From: Neil Crowther [mailto:Neil.Crowther@arun.gov.uk]
Sent: 09 November 2017 16:32
To: Matthew Driver; Daniel Vick
Cc: 'Ian Carey'; Michael Eastham
Subject: RE: BN/28/17/RES - The former Lillies Caravan Park, Barnham

THE LILLIES, BARNHAM
SOUTHERN AREA RE-PLAN
1:500 @ A4

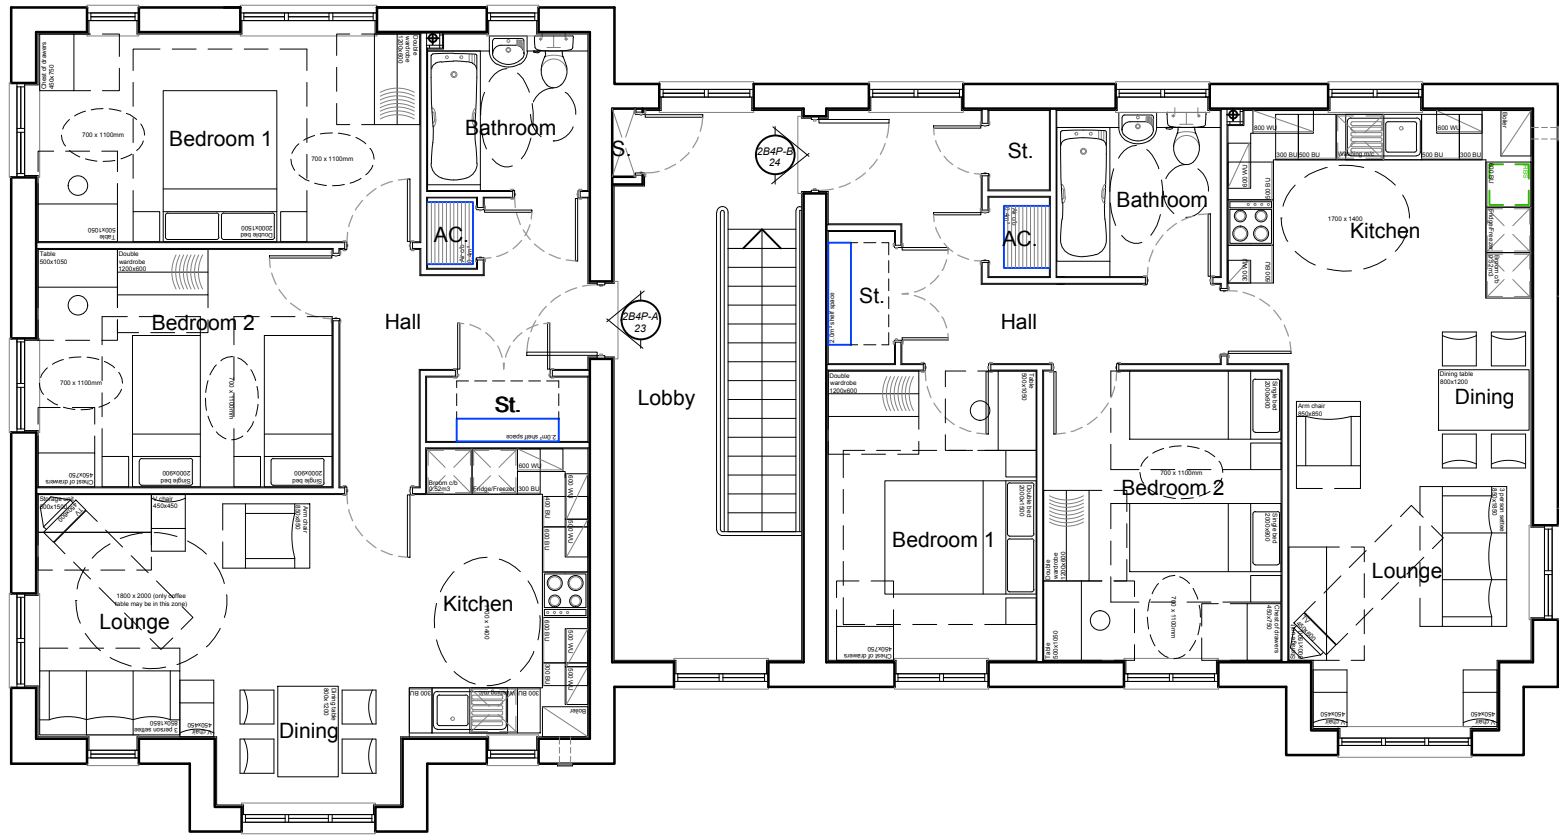
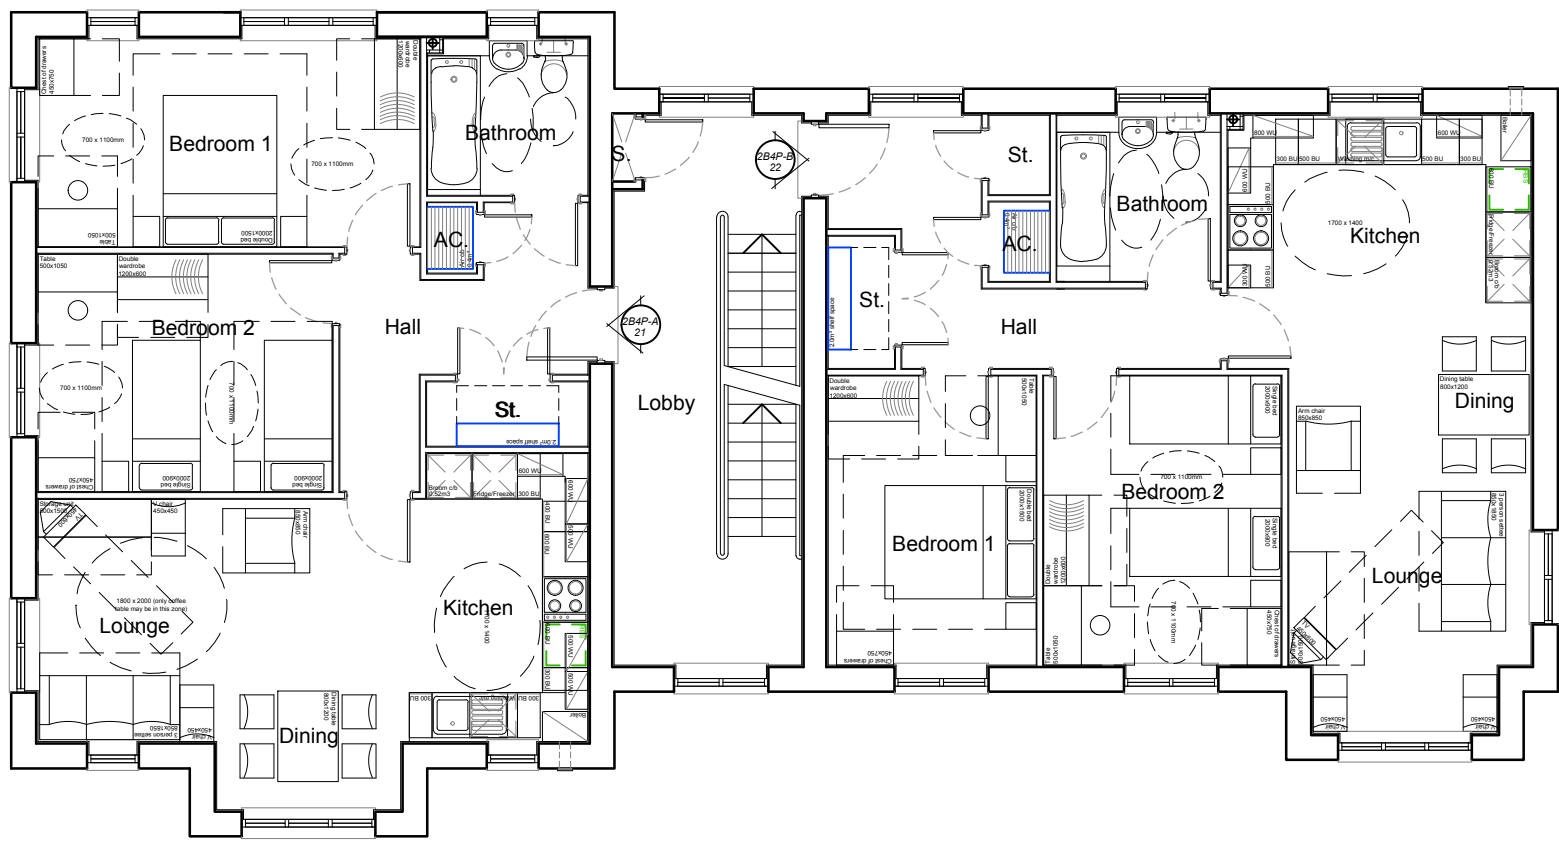
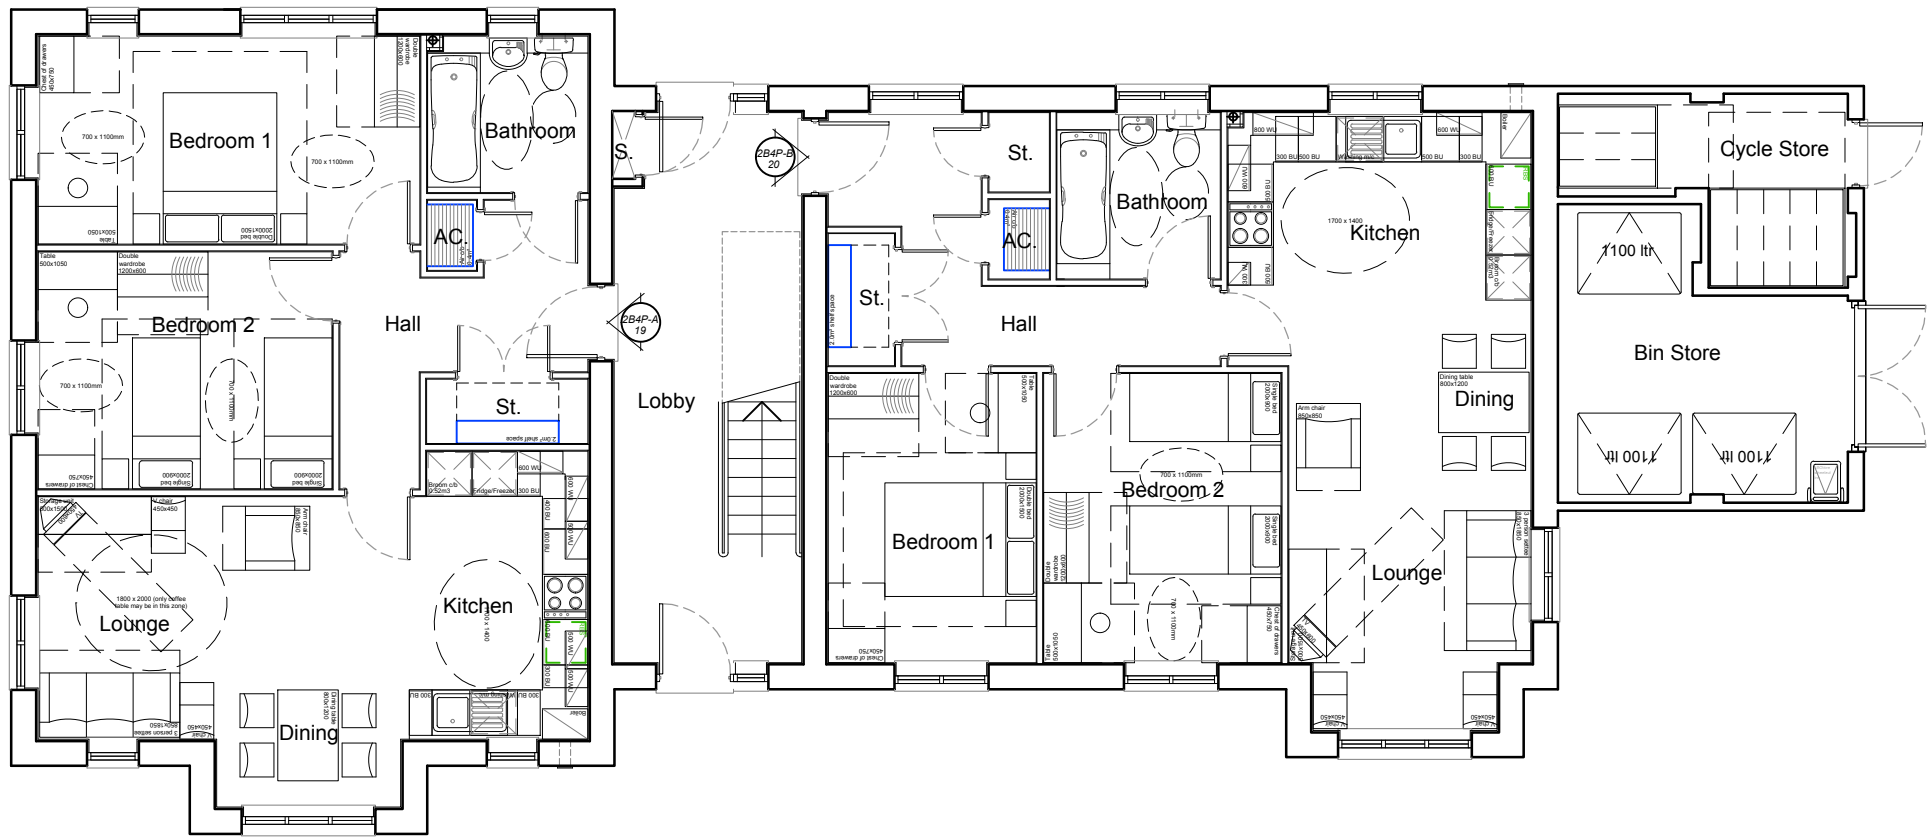
The area of open space is not integral to the scheme and the proposed block of flats is poorly sited so that it not only hides the open space to the rest of the scheme but also has no clear definition of public/private space. These are fundamental issues in respect of the layout proposed and the scheme as it stands will be refused under delegated

powers this week. If the block of flats were removed, the layout would be acceptable and you also have the option to withdraw the application.

- Repositioning of the apartment block so it sits to the southern edge of the development, pushing this back now opens up the area of POS making a more attractive setting as requested.
- The apartment block still acts as a vista stop as we enter the site on Yapton Road progressing south, also as the adjacent development looks into our site from the west.
- Apartment block has active frontage to all sides.
- Low hedge row shown around apartment block defining defensible and private space, note that the apartment block do have Juliette balconies which will open on the POS area.
- Pumping station location revised to western side.
- Attenuation basin shape revised and relocated to south western corner.
